5 December 2025

TfNSW Reference: SYD25-00952/03
DPHI Reference: SSD-96248991

**EXHIBITION OF ENVIRONMENTAL IMPACT STATEMENT (SSD-96248991)
PROPOSED ROUSE HILL HOSPITAL
CORNER COMMERCIAL ROAD AND WINDSOR ROAD, ROUSE HILL**

VEHICLE SWEEP PATHS PLAN A
SWEEP PATHS - ENTRY AND EXIT BETWEEN HOSPITAL SITE AND COMMERCIAL ROAD - PRIME MOVER AND SEMI-TRAILER

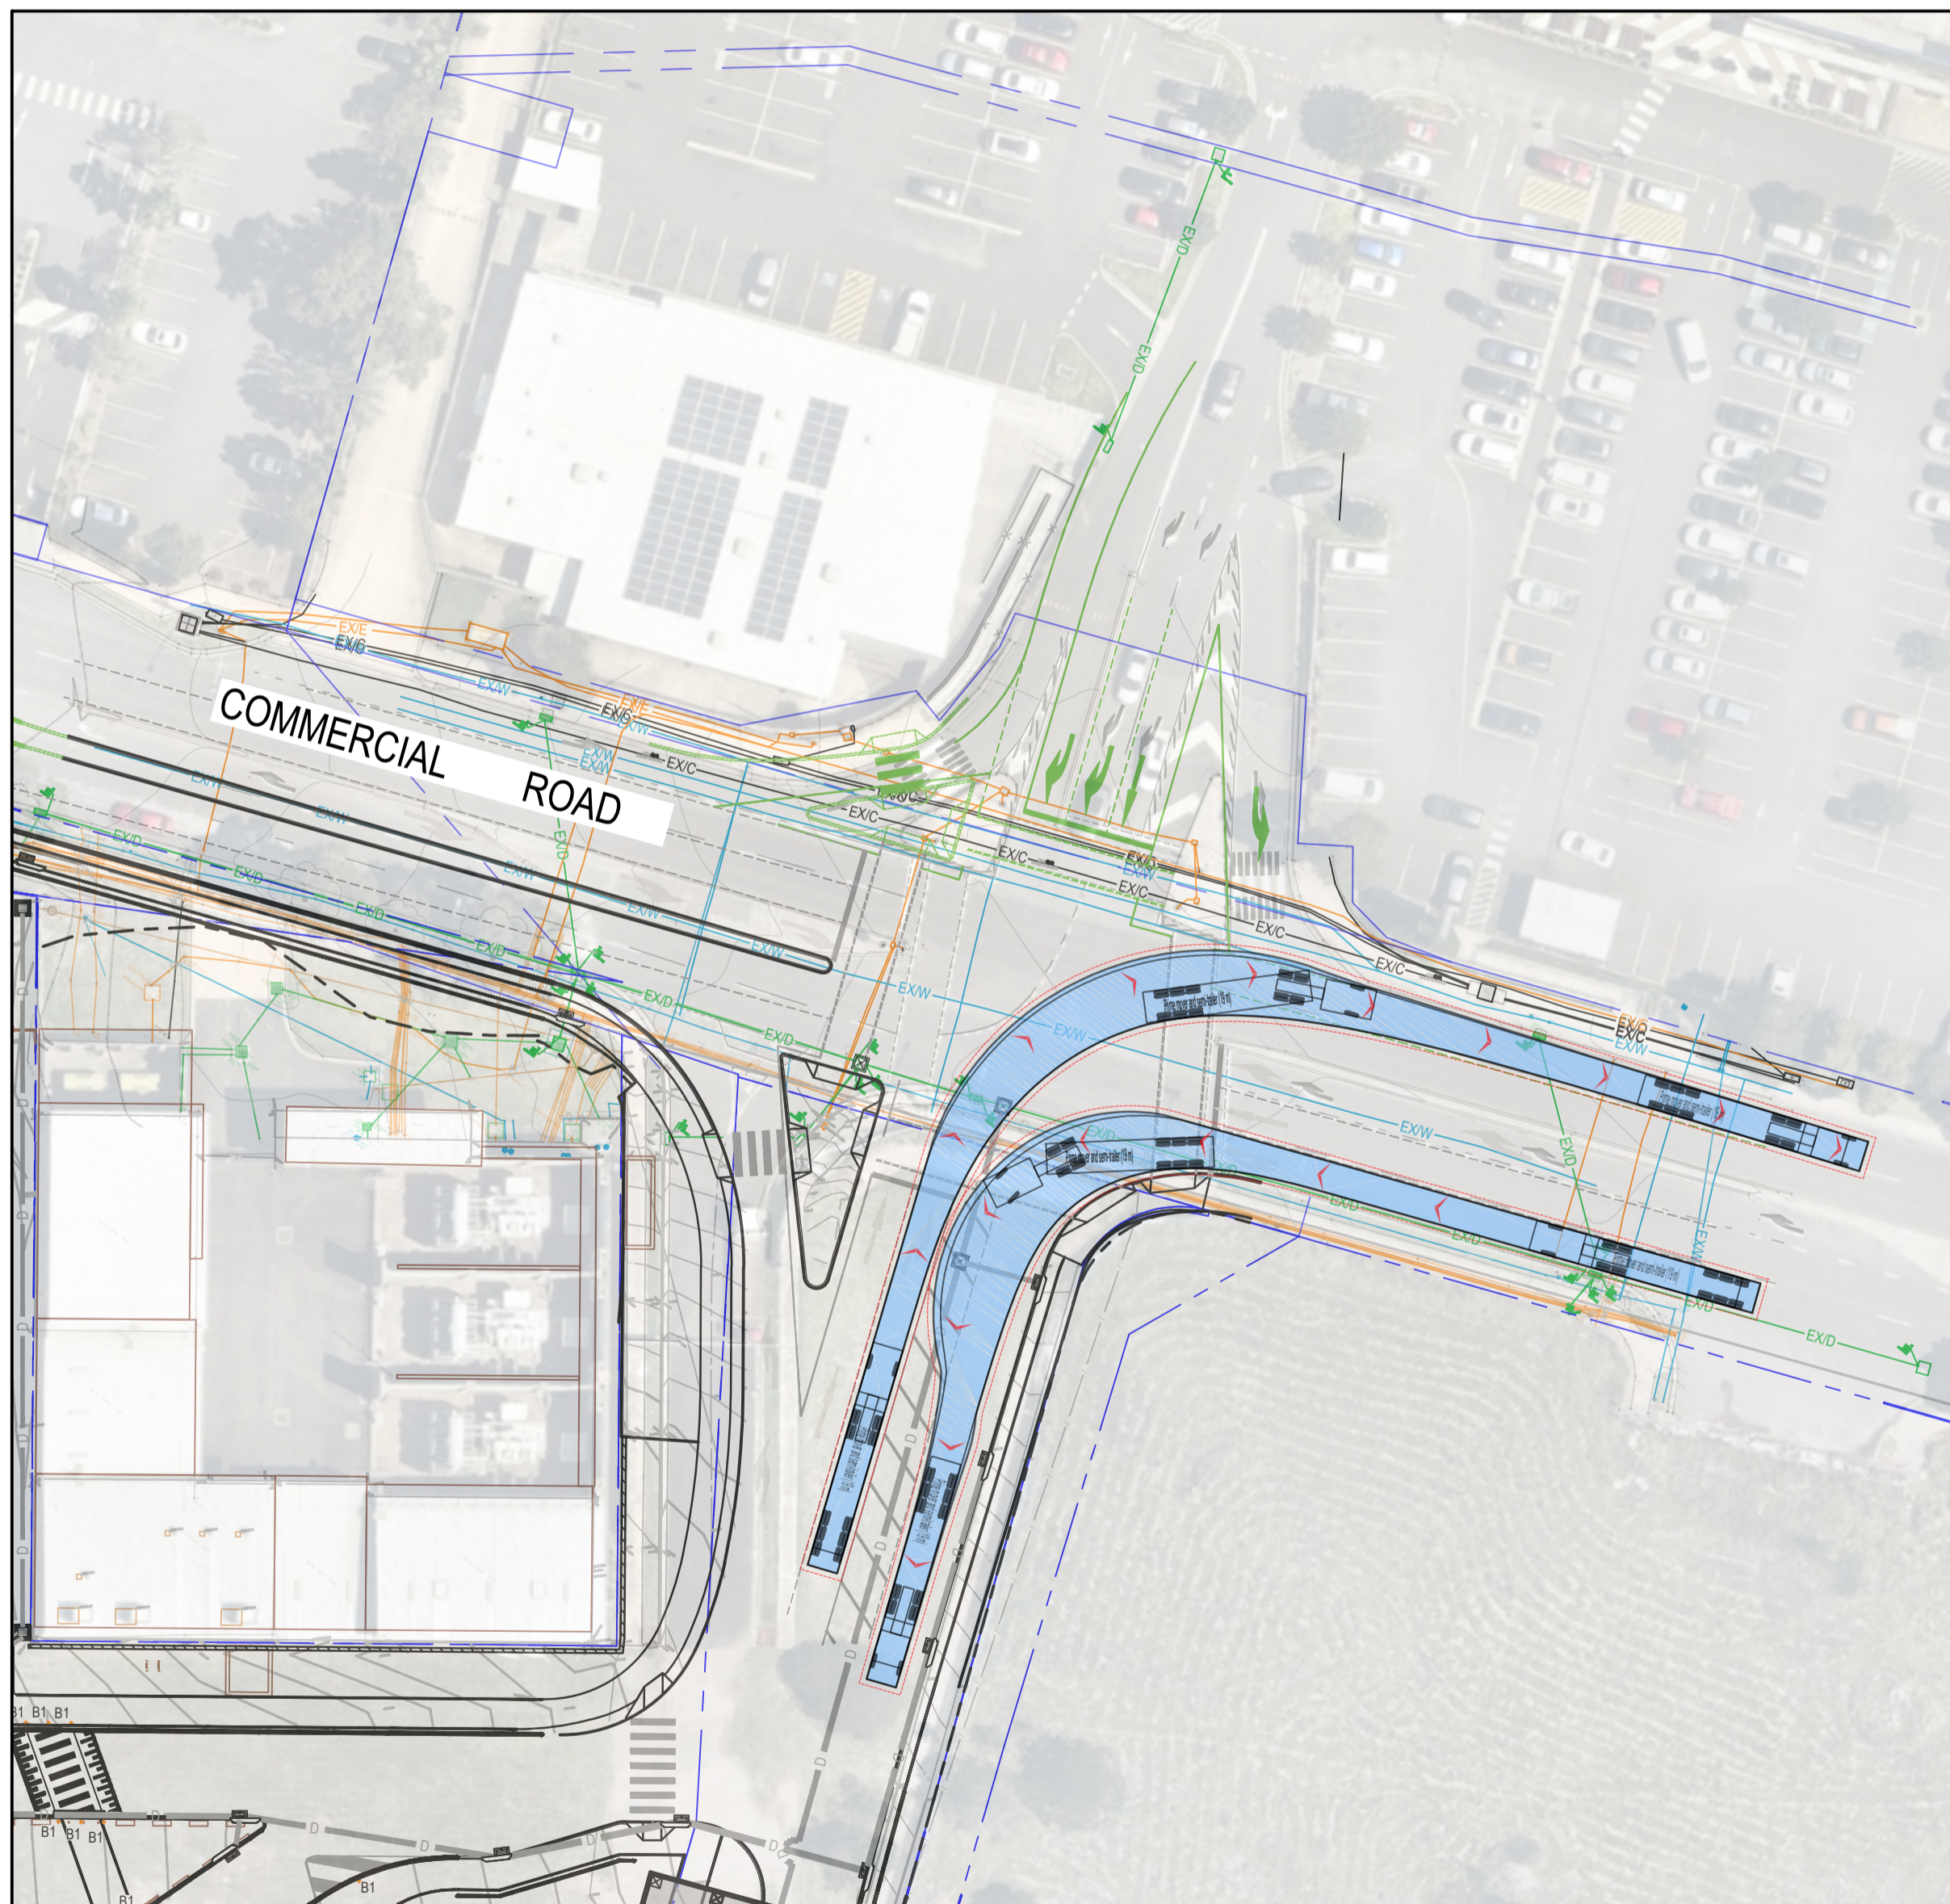
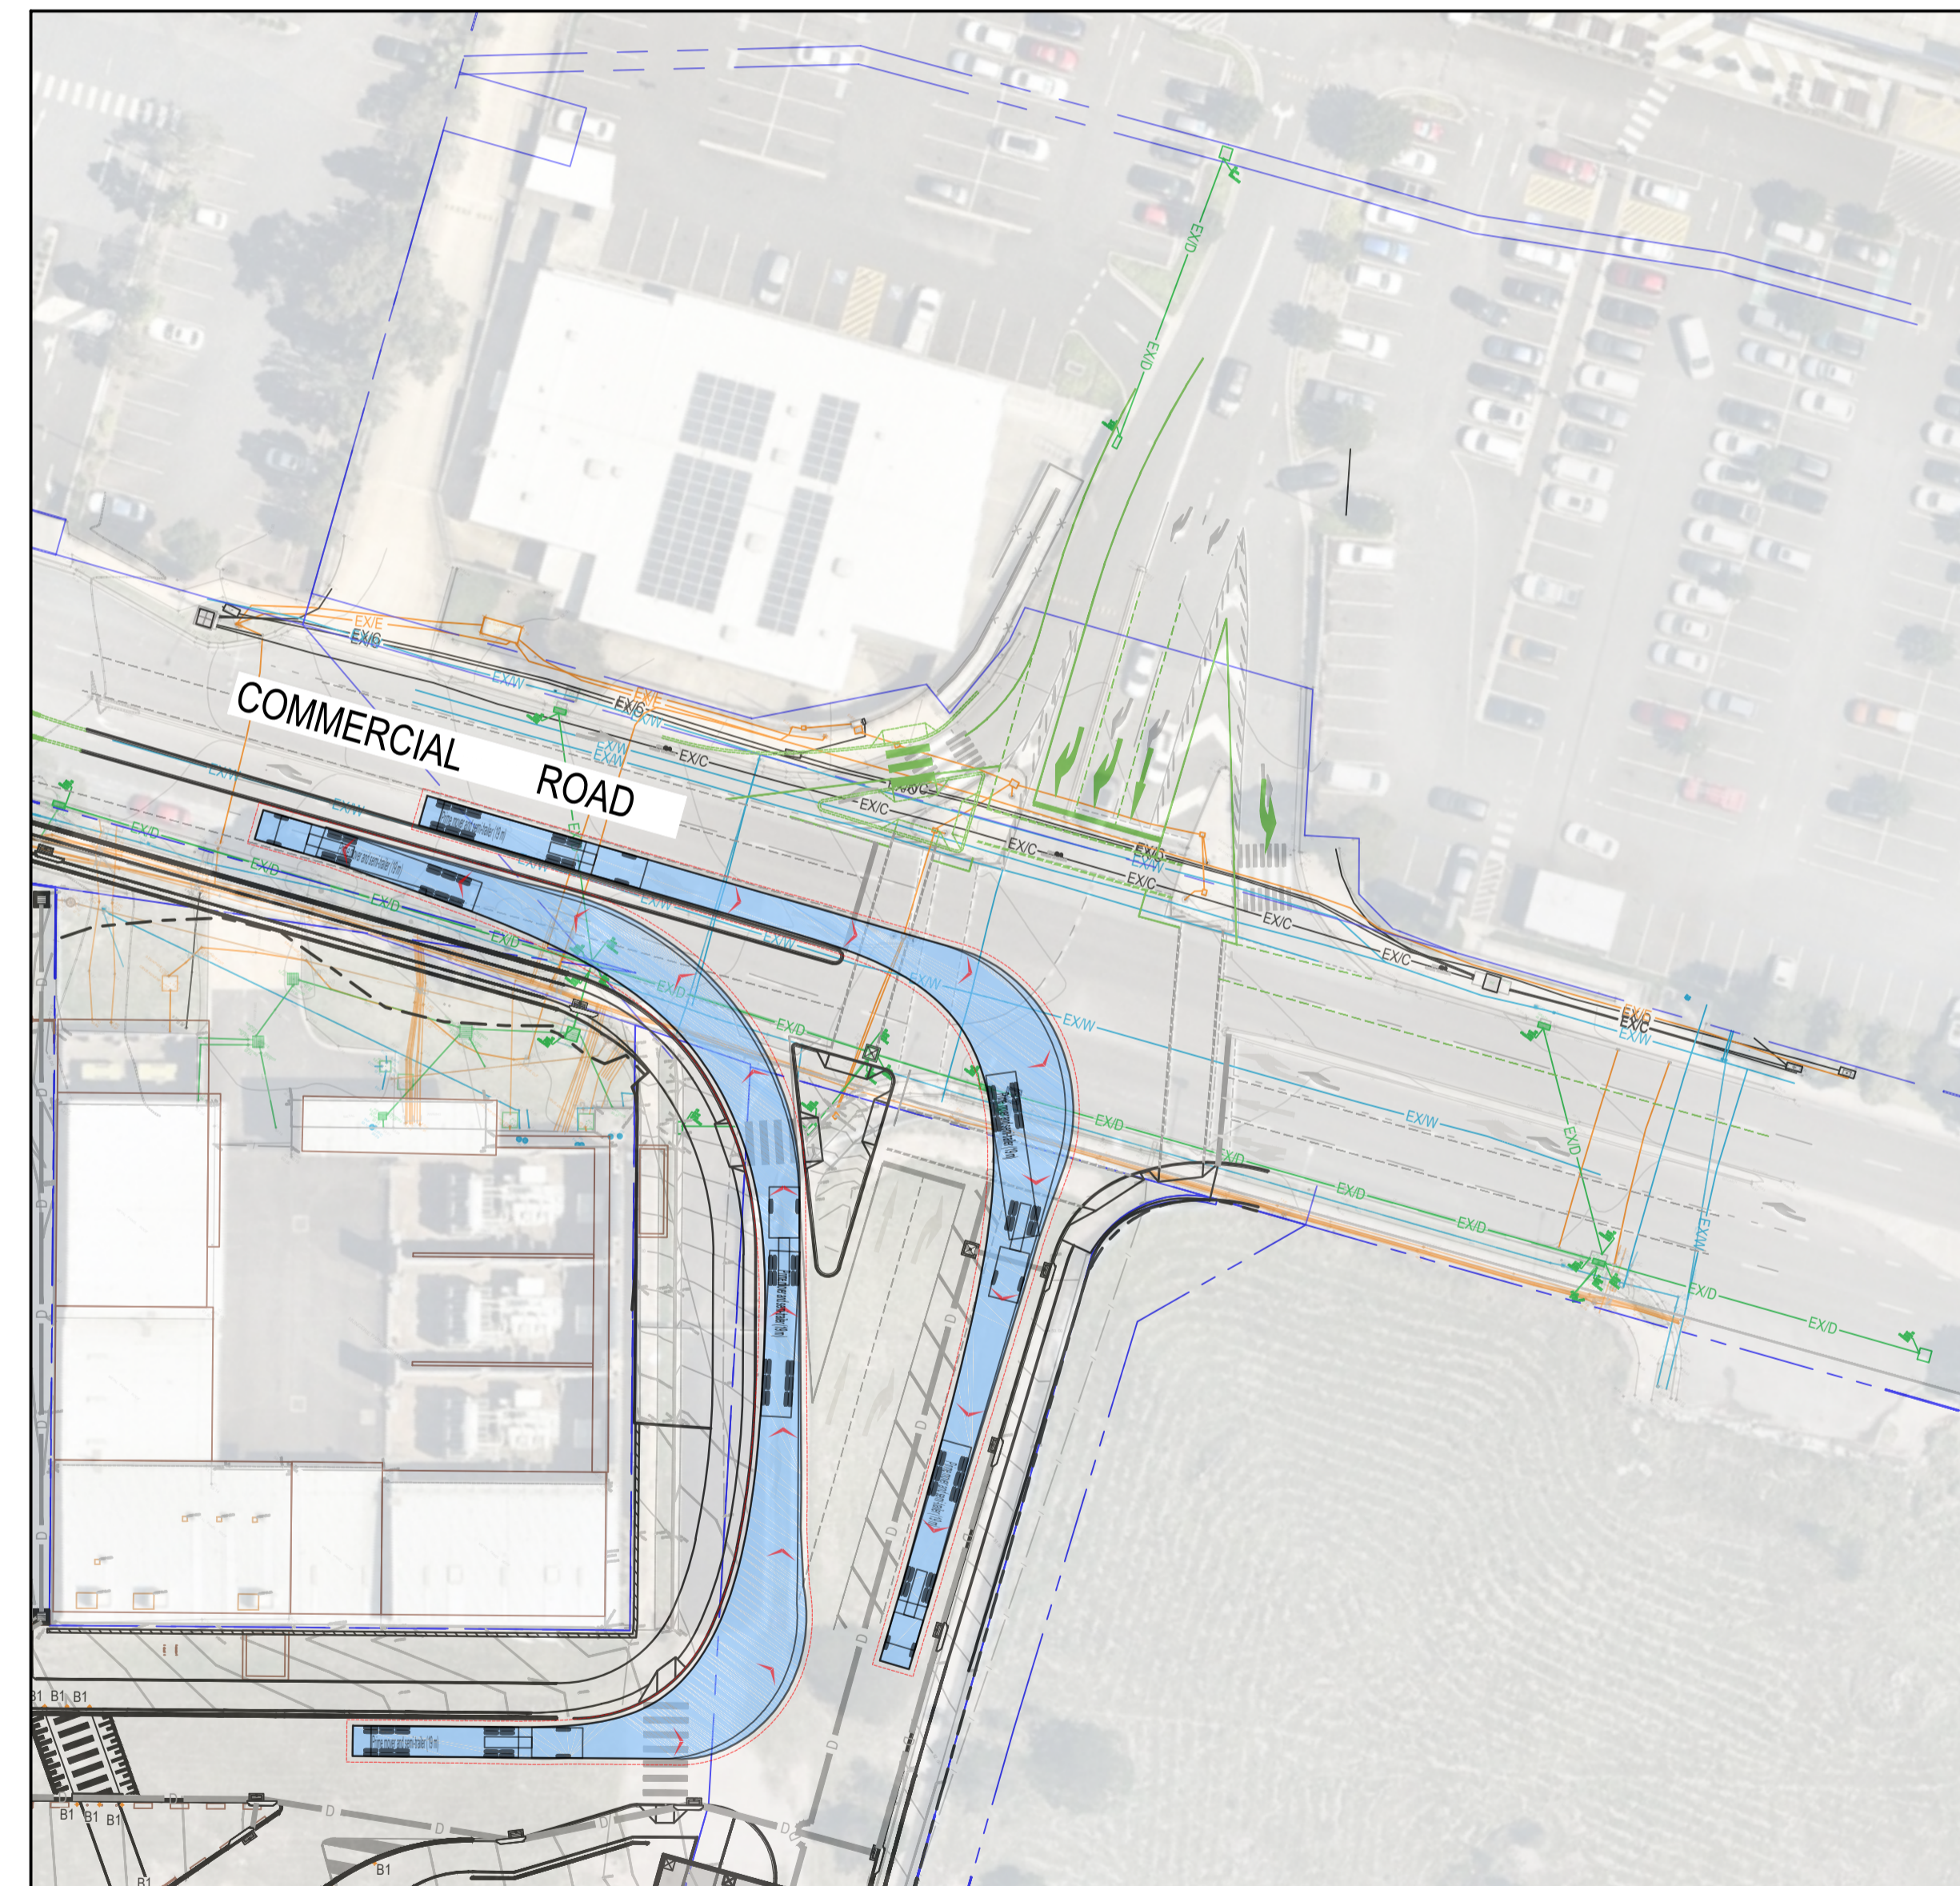
It appears that Truck bays 1, 4 & 5 cannot enter the loading dock if other heavy vehicles are parked in either dock 1 or dock 2. This may result in trucks waiting on the access road until such time as they can enter safely. It is also noted that trucks leaving the loading dock occupy the full road width when turning from the loading dock driveway into the access road.

TfNSW recommends that the Applicant consider managing this via the Operational Plan of Management for the development.
